STORMWATER MANAGEMENT PLAN

Commercial & Maple Street
Mixed Use Development
Portland, ME

Woodard & Curran Comments dated 12/12/12

Routing Diagram for Marriott Courtyard Portland Post 01-14-13
 Prepared by Opechee Construction Corporation
 HydroCAD® 10.00 s/n 01241 © 2012 HydroCAD Software Solutions LLC

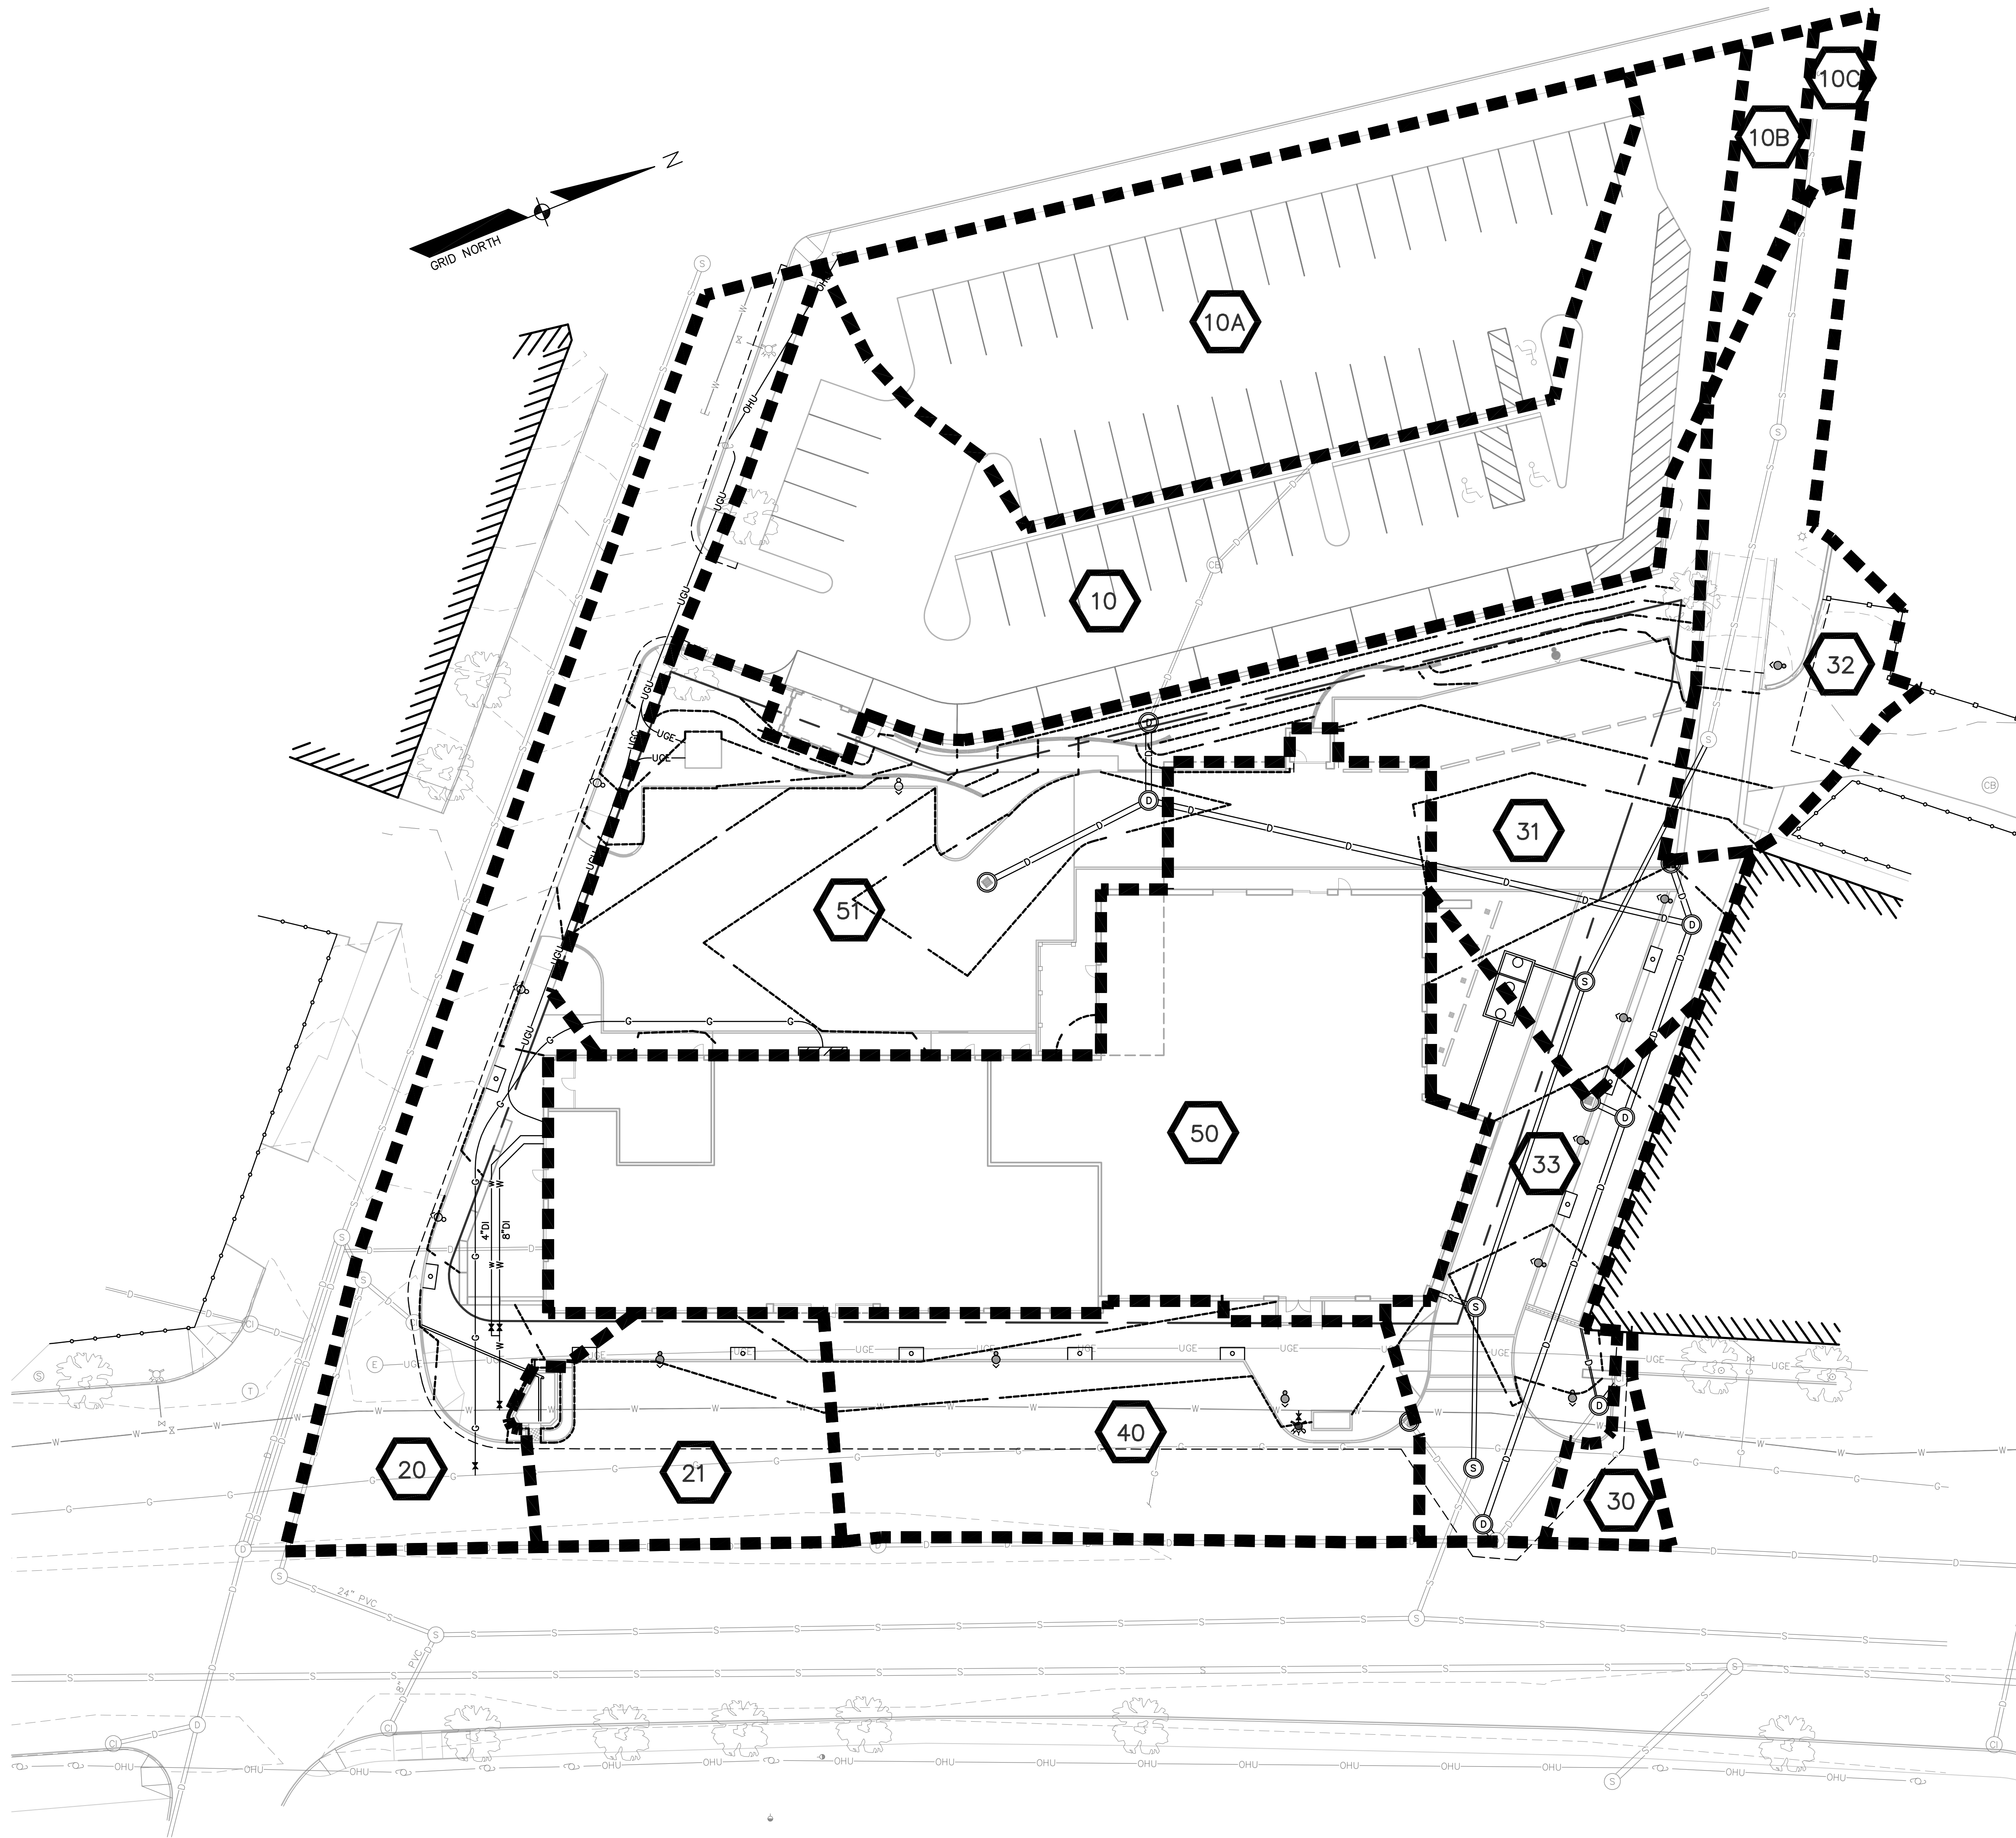
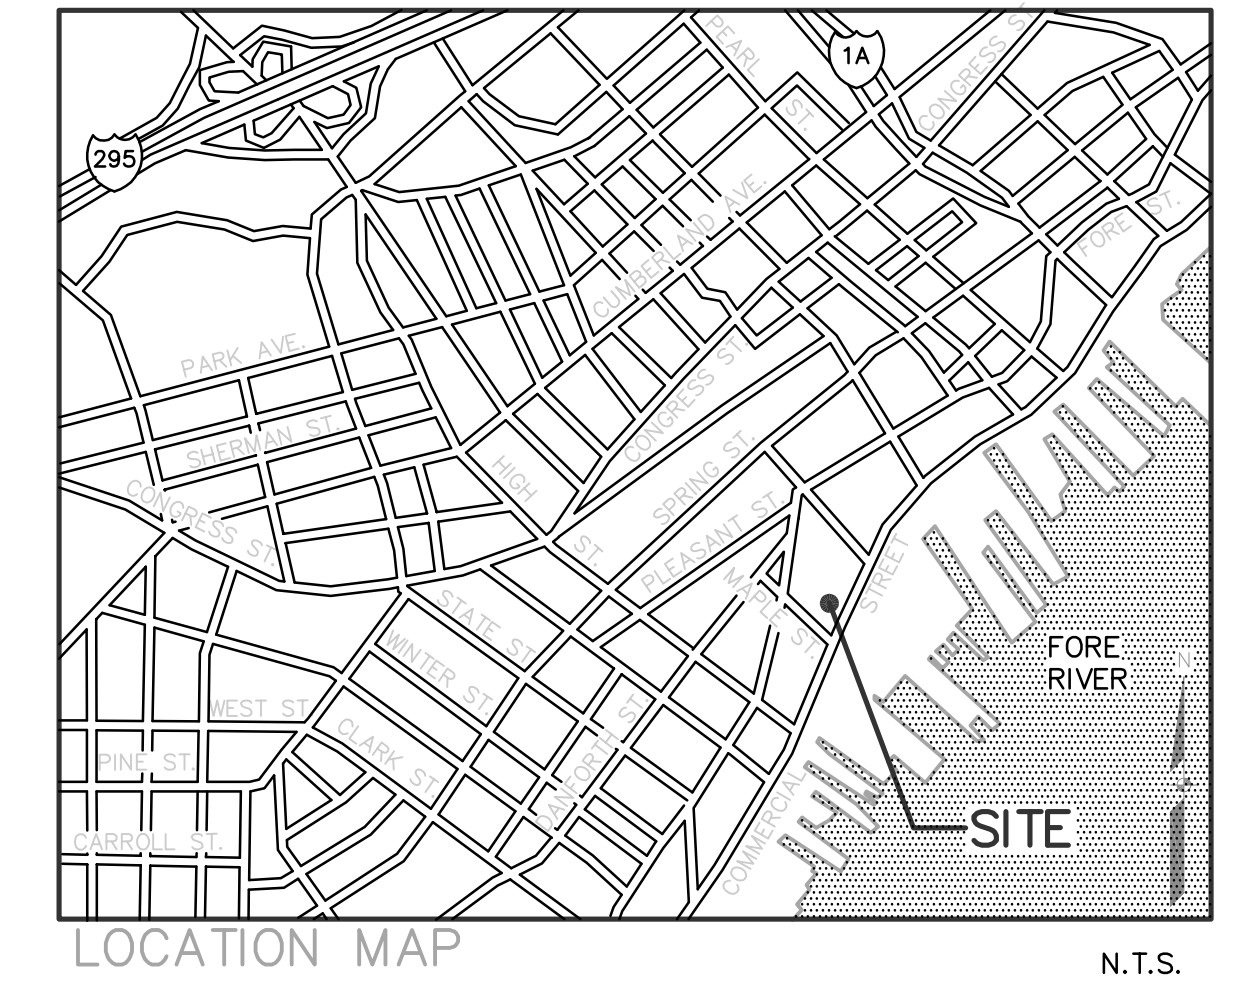
1. The Applicant has identified a "green area stormwater treatment" system Within a bump-out on Commercial Street to provide water quality treatment for approximately 6,810 sq; ft of sidewalk,, roadway, and on-street parking area. This system would provide treatment for an area in excess of the proposed new impervious area resulting from the project (2,513 sq ft). Pending review of the design details associated with this system, the proposal provides an acceptable means of meeting the City of Portland's water quality treatment requirements. We understand that additional information and plan revisions are forthcoming, and we anticipate reviewing engineering calculations for the treatment system, specifically the ability to provide water quality treatment for the 1", 24-hour storm event. In addition, we will review design details and modifications to the Inspection and Maintenance Plan. The system is proposed within the municipal Right-of-Way, so the Applicant will need to execute an agreement with the City of Portland specific to inspection and maintenance responsibilities.

A green area stormwater treatment area is now being proposed within the bump out at the Commercial Street and Maple Street intersection. Please see the attached Post-Development Drainage Plan showing the impervious area (Subcatchment 21) to be treated. There will be a total of 3,950 sq.ft. of impervious area directed to the stormwater planter. The planter cross-section will be revised as per the attached plan view and details. The revised planter will have 18 inches of soil media and a 6 inch perforated PVC underdrain, within 24 inches of crushed stone. This will allow the volume of runoff created by the 1", 24-hour storm event to be treated. Please see the attached HydroCAD printout that demonstrates the planter's capacity.

Inspection and maintenance of the stormwater quality treatment feature has been added to the Inspection and Maintenance portion of the Stormwater Pollution Prevention Plan
